**From:** Anita Gardner <Anita.Gardner@arun.gov.uk>  
**Sent:** 19 May 2021 11:51  
**To:** Planning.Responses <Planning.Responses@arun.gov.uk>  
**Subject:** FW: AB/39/21/DOC - 19 Maltravers Street, Arundel

I am e-mailing you in respect of the above approval of details reserved by condition imposed under ref AB/125/20/L relating to Condition Nos 3 - details of junction between elevation of extension & flat roof including materials, 4 - materials & finishes for brick & brick bond, 5 - details of new external door including materials, finish & method of glazing, 6 - materials & finishes for rooflight and 7 - details of internal window including proposed glazing

Section A-A

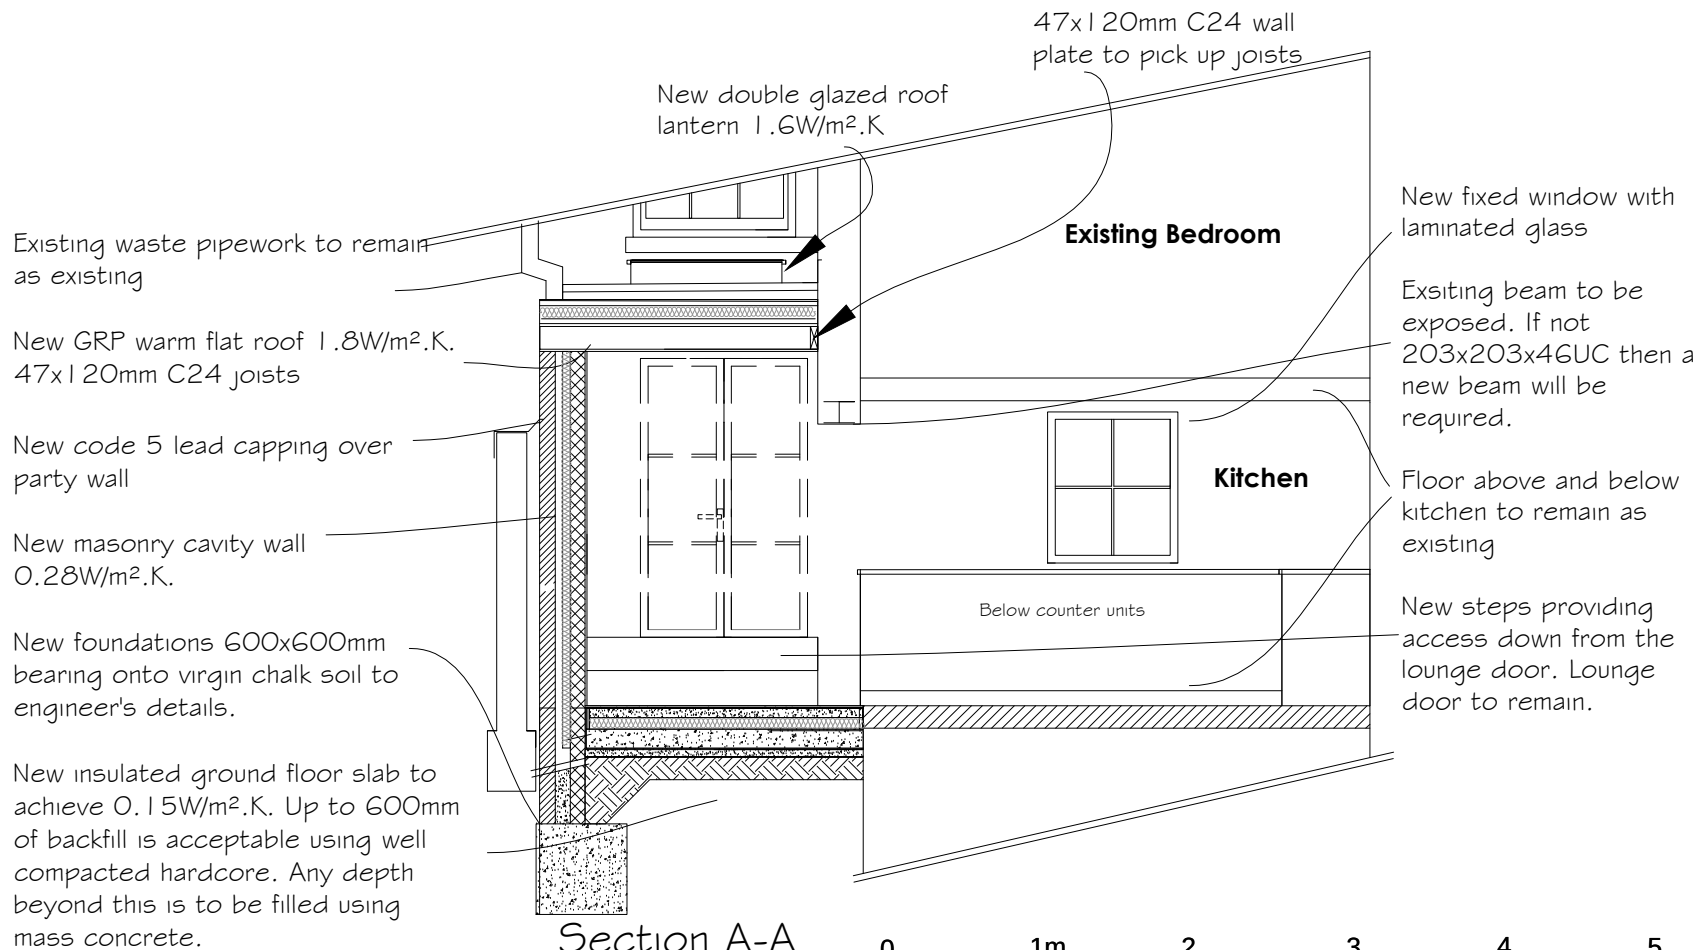
Having reviewed the additional information you have submitted and discussed it with the Conservation Officer it is noted that you have not confirmed if the glazing bars will be integral or applied to the glass. Can you let me know as soon as possible please.

In respect of condition 7 it would help to have further information regarding the interior window: what will the glazing bars look like? Will they be integral or applied to the frame?

I also note that the intention is to revise the treatment of the small areas either side of the rear elevation door from brick to render and use the same paint colour as already present on the listed building. Whilst this approach is likely to be acceptable, it can't be submitted as discharge of condition application since the treatment of the wall was detailed on the approved plans and there are no conditions relating to submission of render for approval. In order to make this change a new application for Listed Building Consent will need to be submitted for consideration.

The glazing bars will be an integral part of the frame with individual panes of glass.

The window will be joinery quality timber construction with laminated glass. The parting beads will be timber bevelled to match the sash detail to the front of the property.

My client will continue with the facing masonry as shown on the application. There is a miss match (3 different types of brick) across the rear elevation. They plan on using a darker brick to the upper parts of the addition. See photos attached. A brick in similar style and appearance as a Wienerberger Cassandra multi stock will be used. Owing to the small amount of facing brickwork, it would be best to lay in a stretcher bond but are happy to consider a Flemish bond if that is your preference.
